CUMNOR PARISH COUNCIL

BOTLEY WEST SOLAR FARM (BWSF) REF: EN010147

In response to your 11th June 2026 invitation to respond to submissions made to your 28th April 2026 Request For Information, Cumnor Parish Council (CPC) as an Interested Party (IP) is today submitting two documents to you by email:

Drawing file: EN010147 / EN010147-000452-EN010147_APP_6.4 ES - Figures 5.5 - Illustrative Masterplan Cable Corridor Plan Overview - Land between the Central and Southern Site

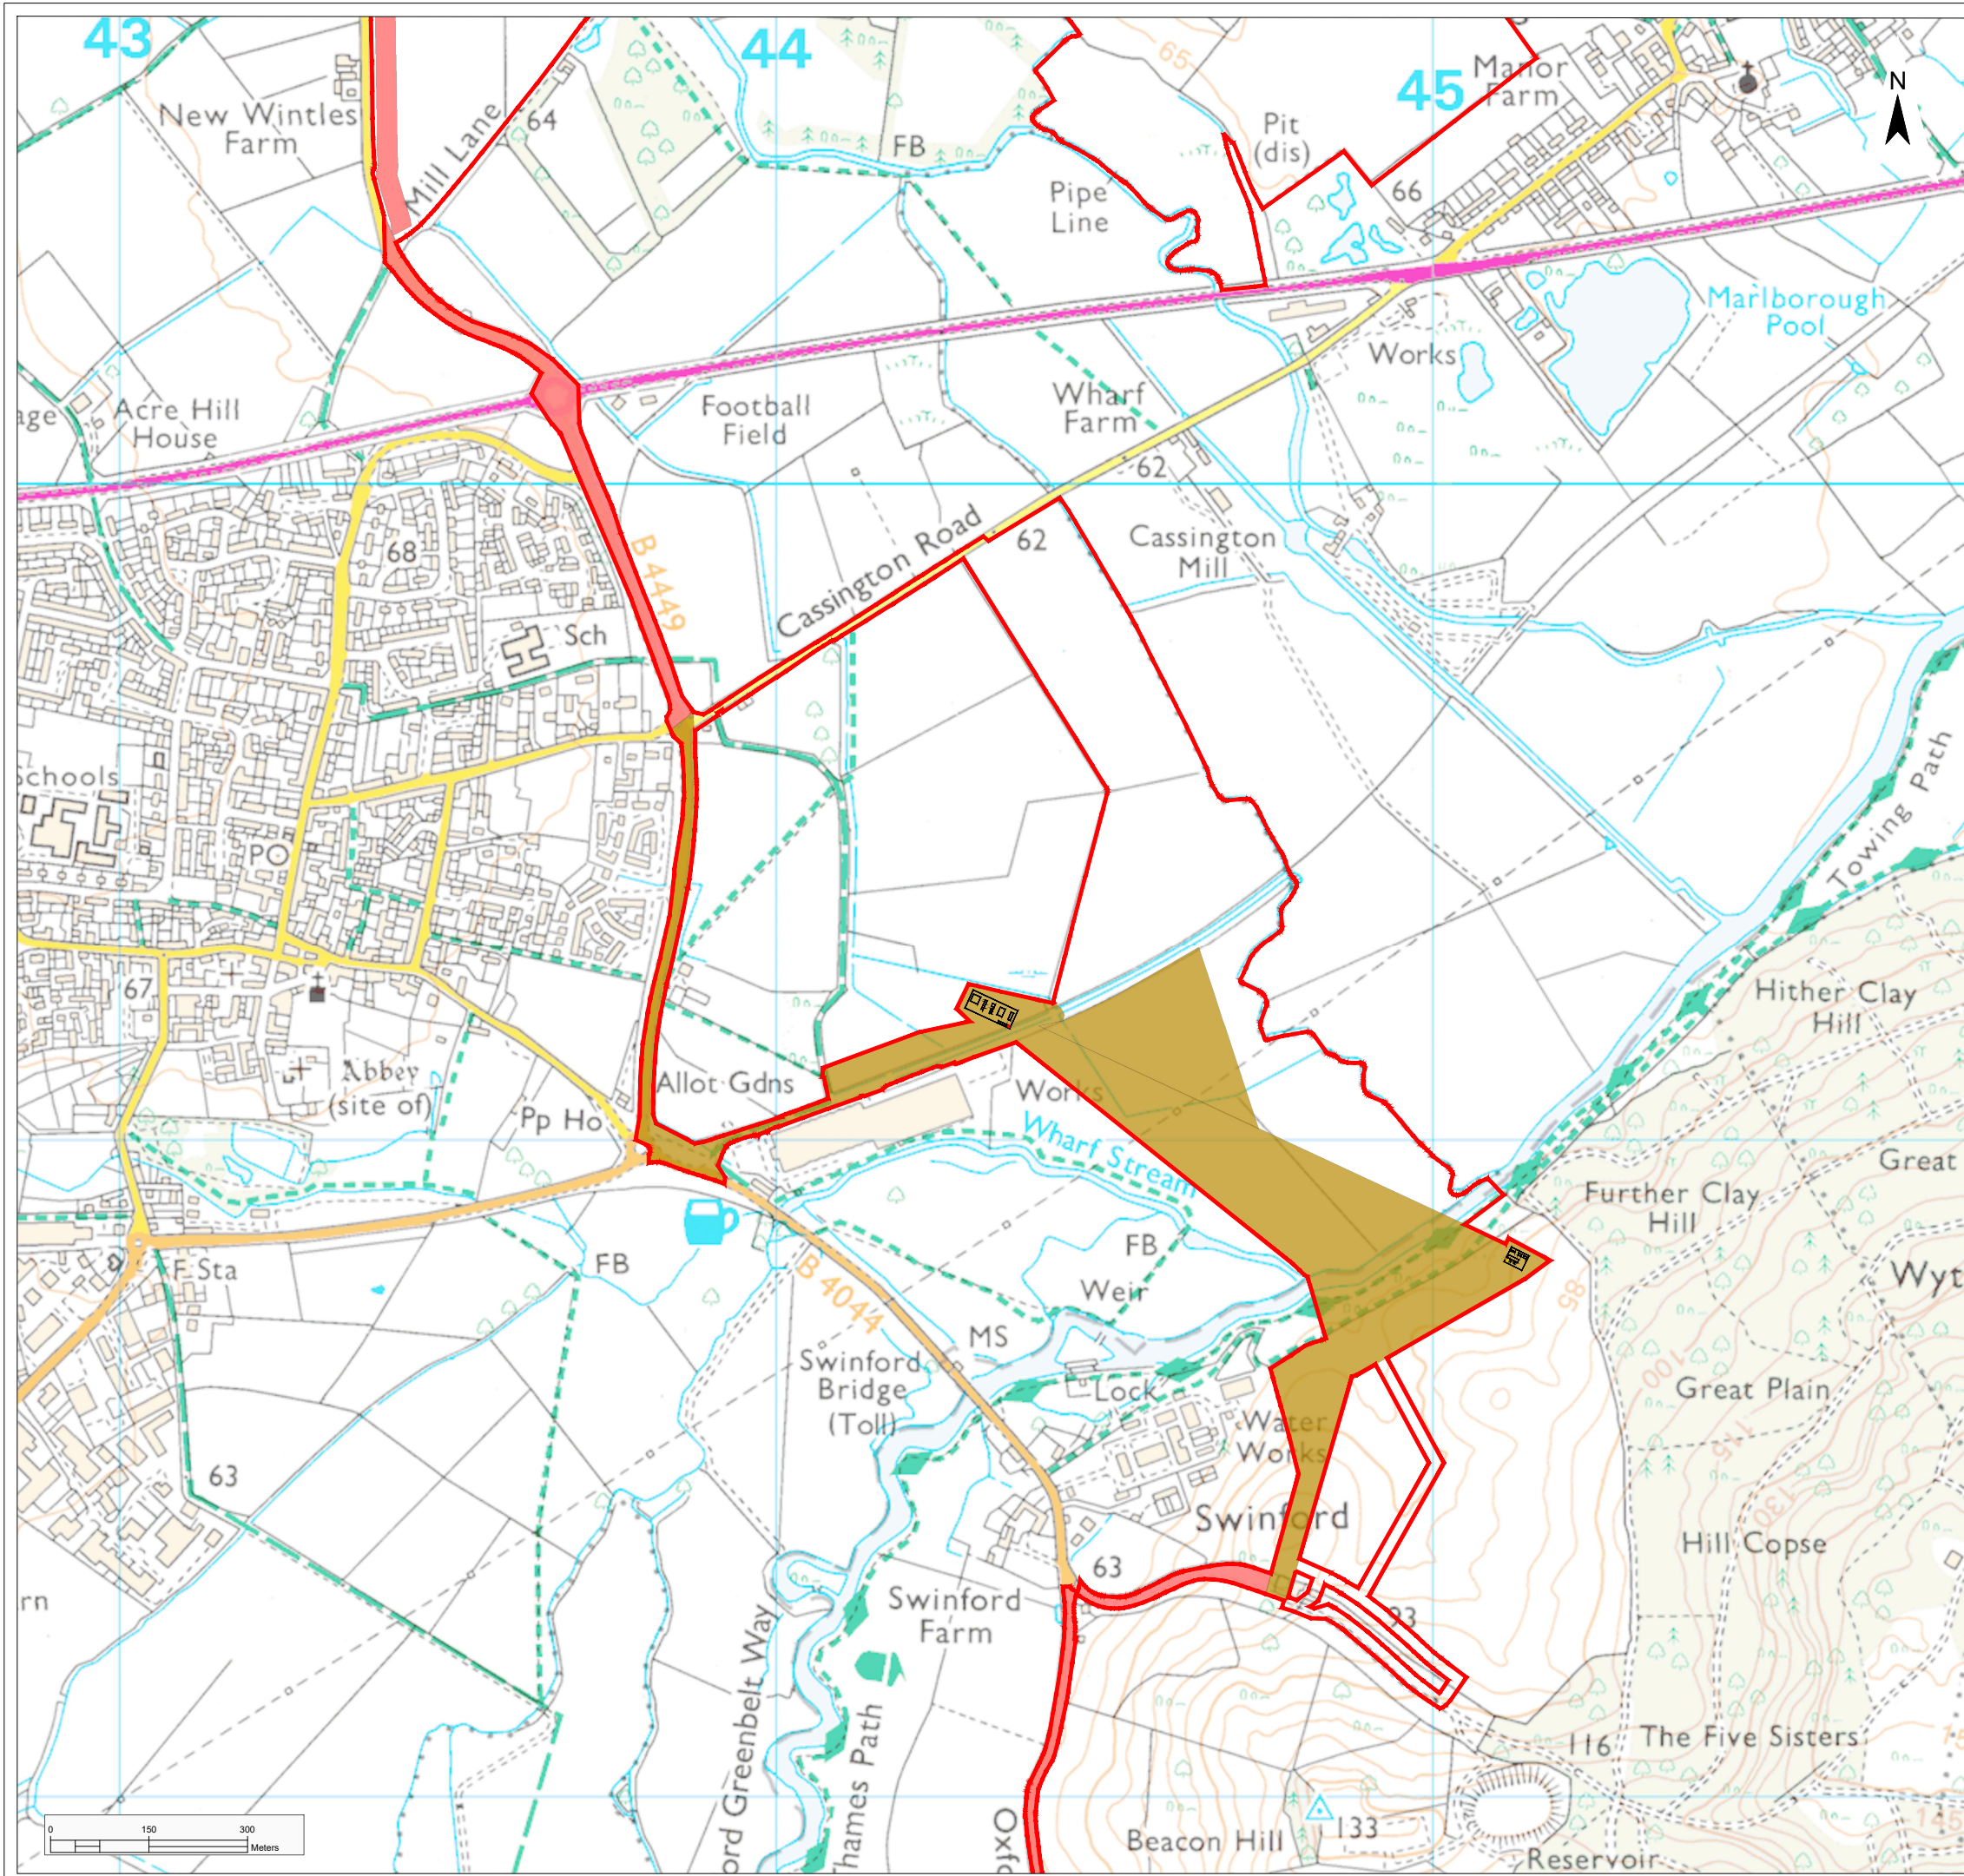
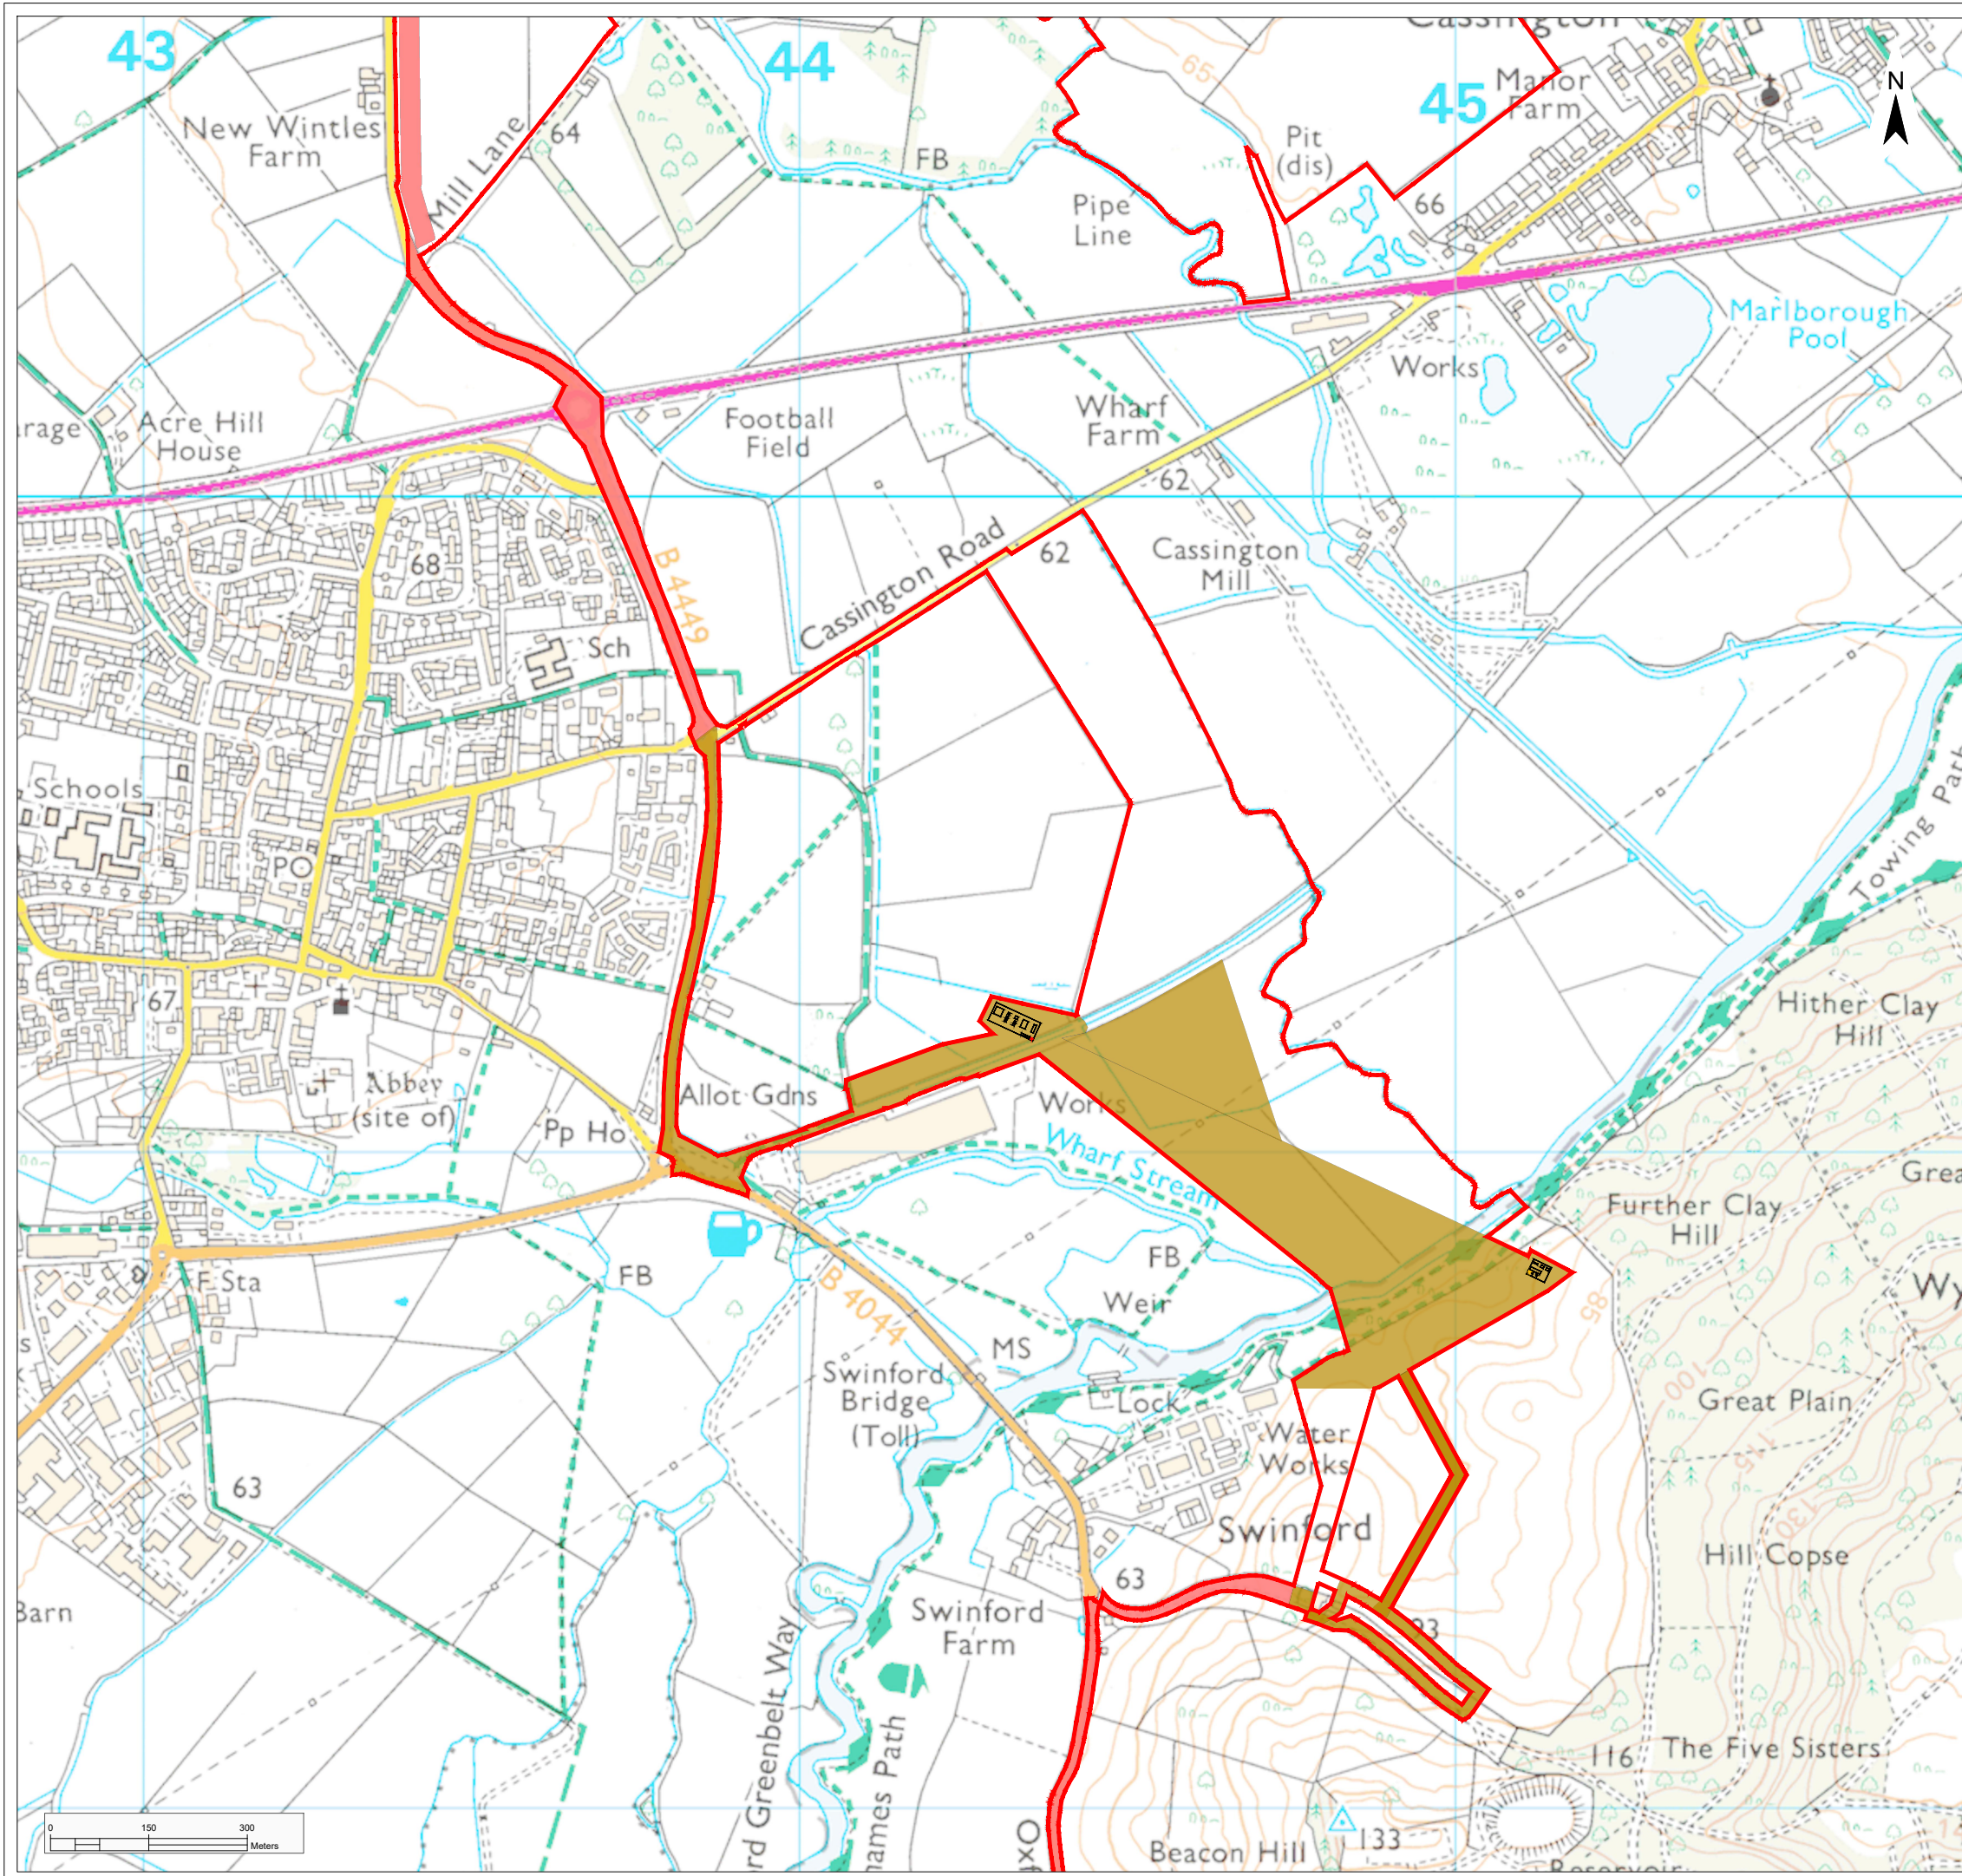
Unfortunately for the Applicant all these impediments are apparently surmountable for their proposed cable connection between the central and southern sites where there are:

- Local Nature Reserves present along the route corridor.
- Ancient woodland blocks (including Wytham woods SSSI)
- River Thames crossing at Swinford: Flood Risk Zones 2 and 3 are present at this crossing - Environment Agency consent required.
- Additional Flood Zone 2 / 3 sections present including the B4044 SW of Swinford (see Map 2 - EA flood risk map - below)

Surprisingly given the Applicant's stated unwillingness to address these impediments for a contrived cable route to Cowley, it is apparently content to cope with them for its central site to southern site cable route.

Except of course it hasn't addressed them in this case either, the prime example being the absence of a '*detailed flood risk assessment*' that satisfies this Interested Party or the OHA for the southern site and the central to southern site cable routing.

Also unexplained is why, if the Applicant is unwilling to bear a cost of c. £10m/km for cabling to Cowley (the Applicant quotes a cost of £150m for 15km to Cowley from the southern site **C1-087 pages 9 and 10**), it is willing to bear that same £10m/km cost, with a total of at least £70m for the c. 7km cable route between the central and southern sites traversing the River Thames near to Swinford Toll bridge in a EA Flood Zone 3 area?
